Planning Application Number: 3/2022/0632

Thank you for your letter dated 8<sup>th</sup> July 2022 regarding the proposed demolition of Pendle Mill for the creation of a 70-bed care home. Having taken time to review the documents on the planning application, we have some questions and concerns we would like to raise.

Drawing Title
 Proposed Site Plan with Culvert and Trees

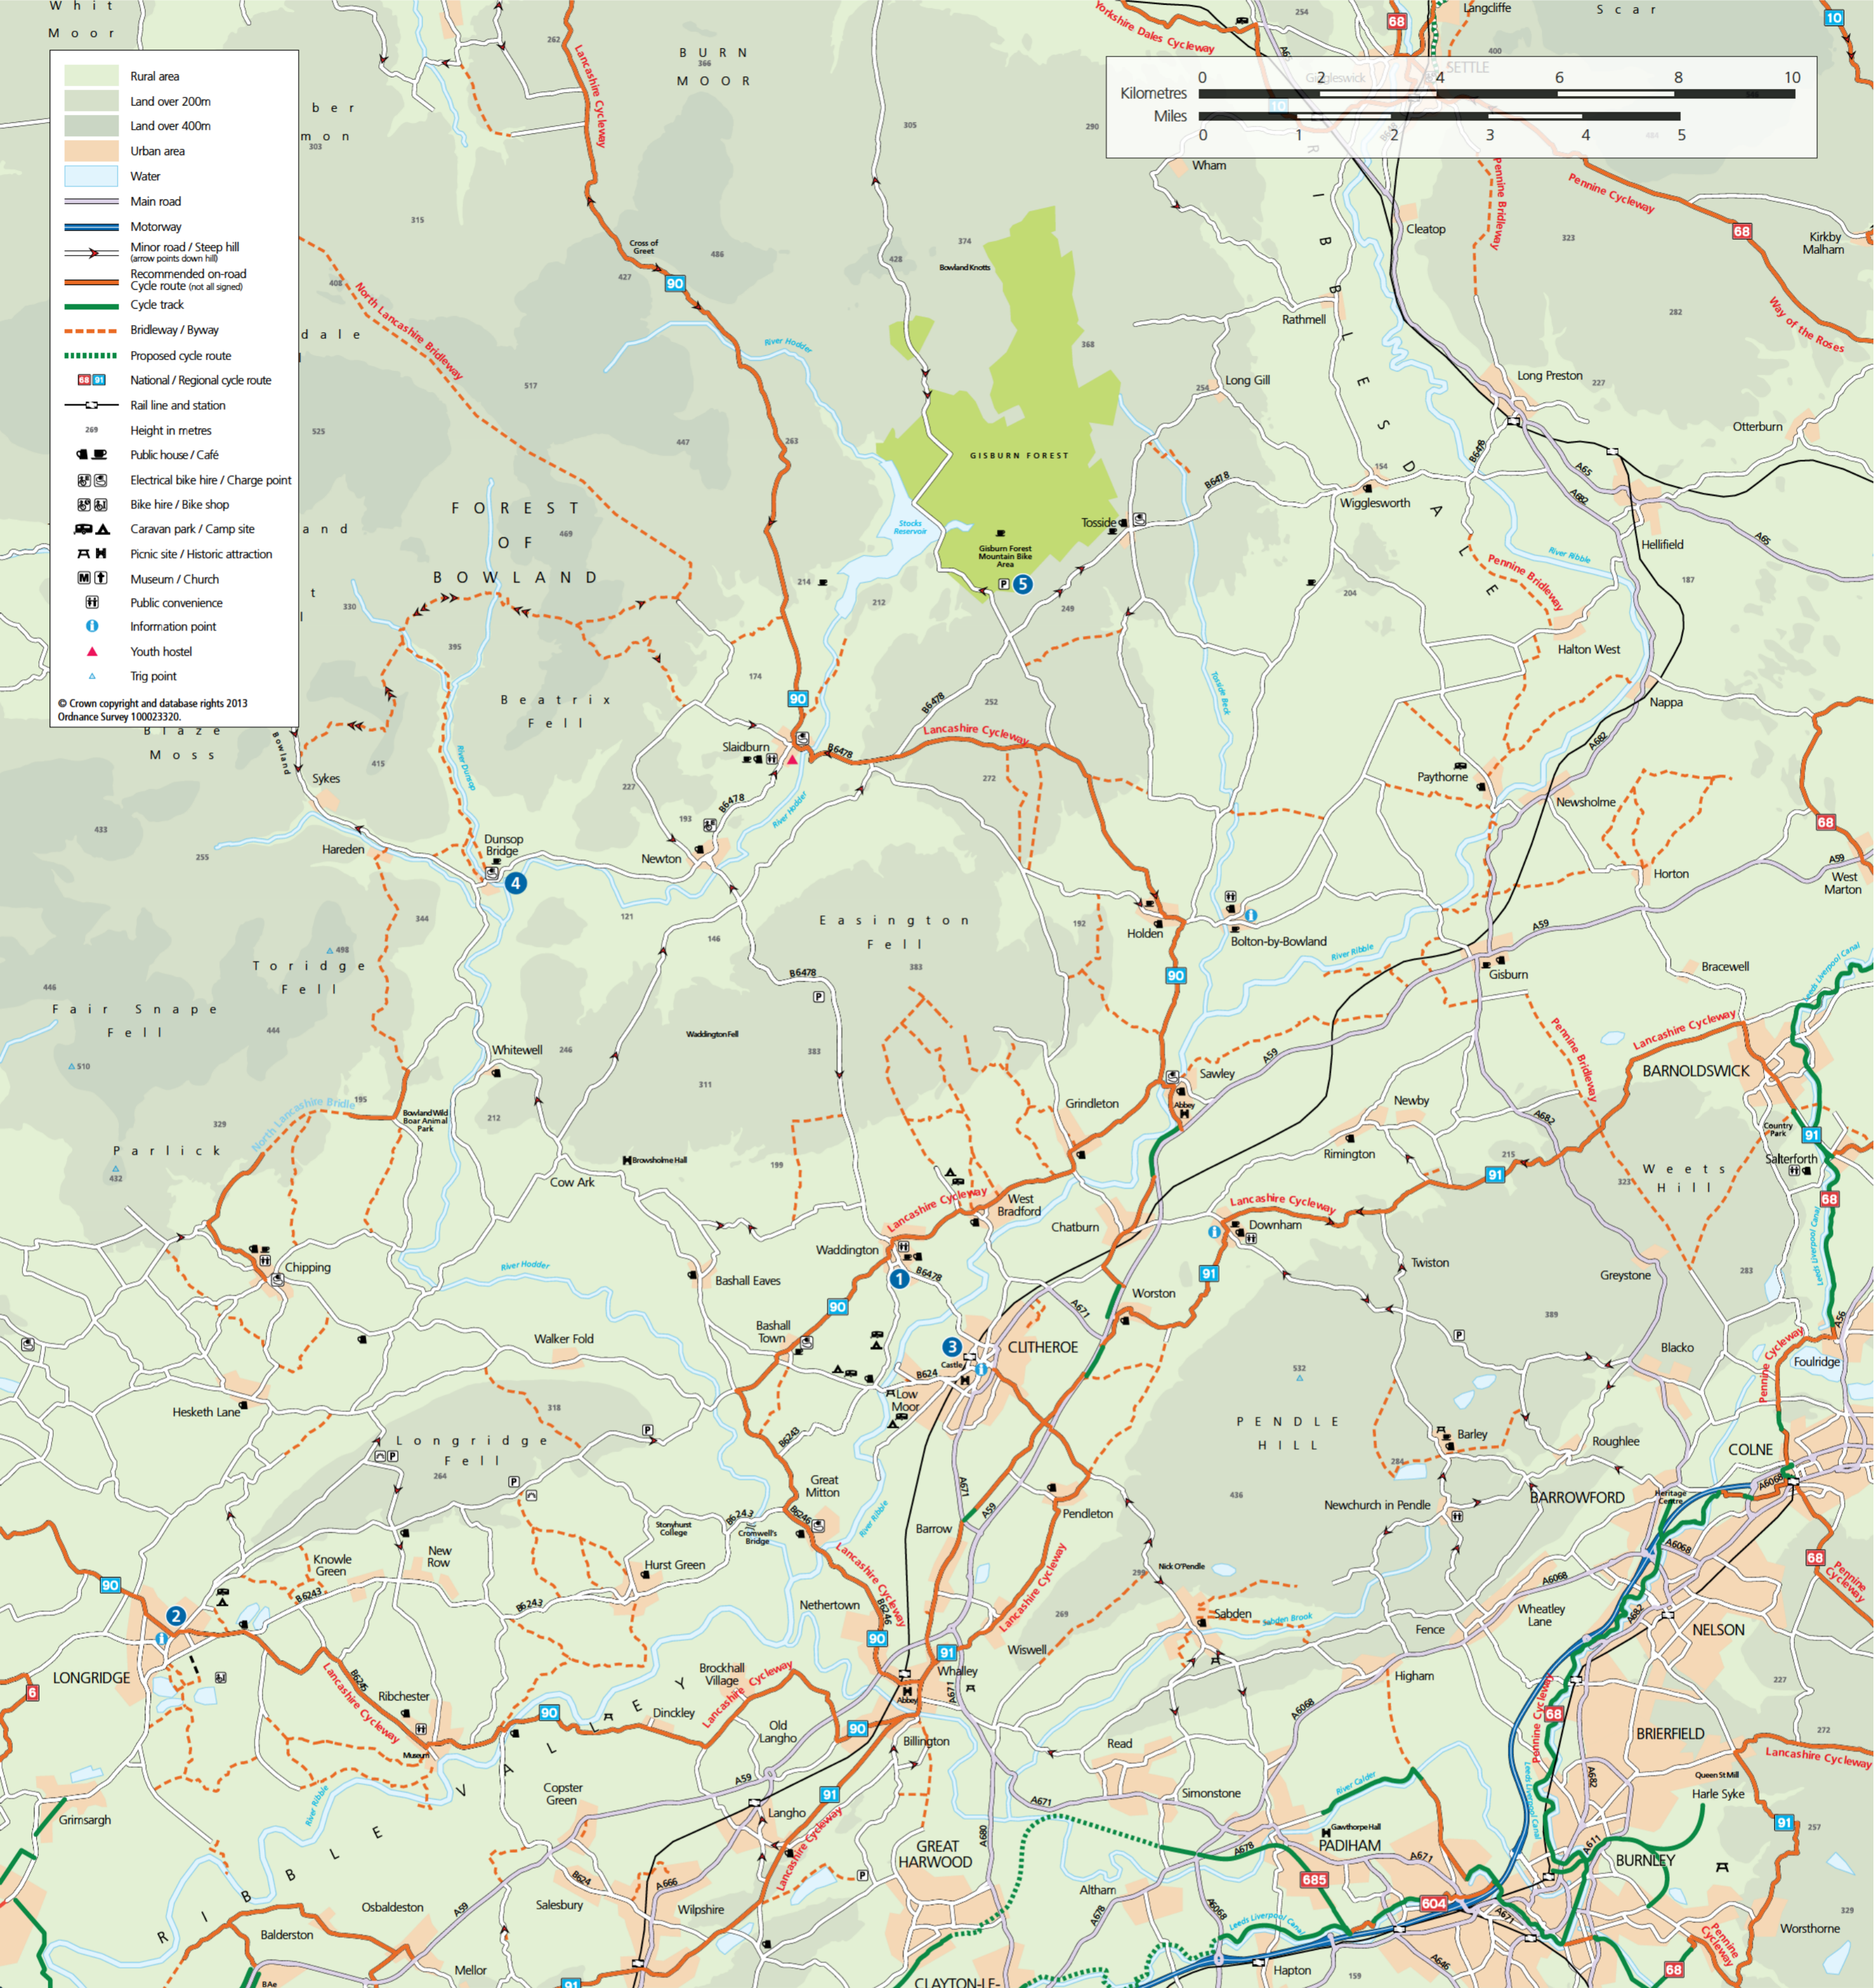
There is the matter of access to – and parking within – the site, and the proposed change from the existing entrance facing [REDACTED] Pendle Road to directly onto Pendle Road itself. Pendle Road is, as mentioned in the Design and Access Statement, one of the main roads into the town (particularly since the creation of the roundabout on the A59 and the erection of housing at Half Penny Meadows – see Appendix 2 showing the close proximity of this growing development), meaning that traffic is heavy throughout the day.

1. According to Page 20 of the Design and Access Statement, the proposed access would open directly onto Pendle Road, at the same level as the road. As can be seen on the attached photographs and excerpt from Page 8 of the D & A statement (Appendix 4), the current wall alongside the road varies up to 2.5m high and includes a gas main. How would the access road and the main road be made to be on the same level? Would significant works need to be carried out in order to make this happen?

2. This development would result in both increased construction vehicle traffic during its creation, as well as increased long-term traffic from both employees and visitors to the home’s residents. The elevated levels of traffic will, in turn, result in increased noise levels as well as increased wear and tear on the road itself and, due to the existing lack of pedestrian crossing amenities, mean that the road will become more even more difficult for pedestrians to cross. Appendix 6 shows the location of the nearest pedestrian crossing to the site.
3. The proposed access point would impact the number of on-street parking spaces available on Pendle Road by 3 or 4 (based on a car length similar [REDACTED] - approx. 4.3m -and allowing for the loss of one space per side of the access entrance) – See Appendix 7 for a visual representation of the on-street parking loss.

5. The size of the car park allocated for the building has been specified as having 28 spaces, two of which will be disabled spaces. Based on the calculations within Section 5.27 of the Planning Statement; 15 spaces will be required for staff and 14 for visitors based one 1 in every 5 residents having visitors. This is based on Section 3.2 of the same document, where it is stated that “There would be a minimum of 23 staff on-site at any one time”. The word minimum has been underlined to emphasise that this is the smallest number of staff proposed to be on site; and yet it is how the number of parking spaces has been calculated.

The developers’ calculations come to 29 parking spaces required; meaning that even using these minimum estimates provided in the Planning Statement, between one and three cars (based on utilization of disabled spaces) would require on-street parking on Pendle Road. Which, as detailed in Point 3 of this letter, is already at a premium due to the loss of spaces resulting from the access point move.

We must further consider that during peak staffing and visitor periods, these numbers could rise significantly. For instance, a shift of 30 staff and visitors rising to 1 in 4 residents would result in an additional 8 on-street parking spaces required. Therefore; is there an estimate for the greatest number of anticipated staff on site with which to calculate parking?
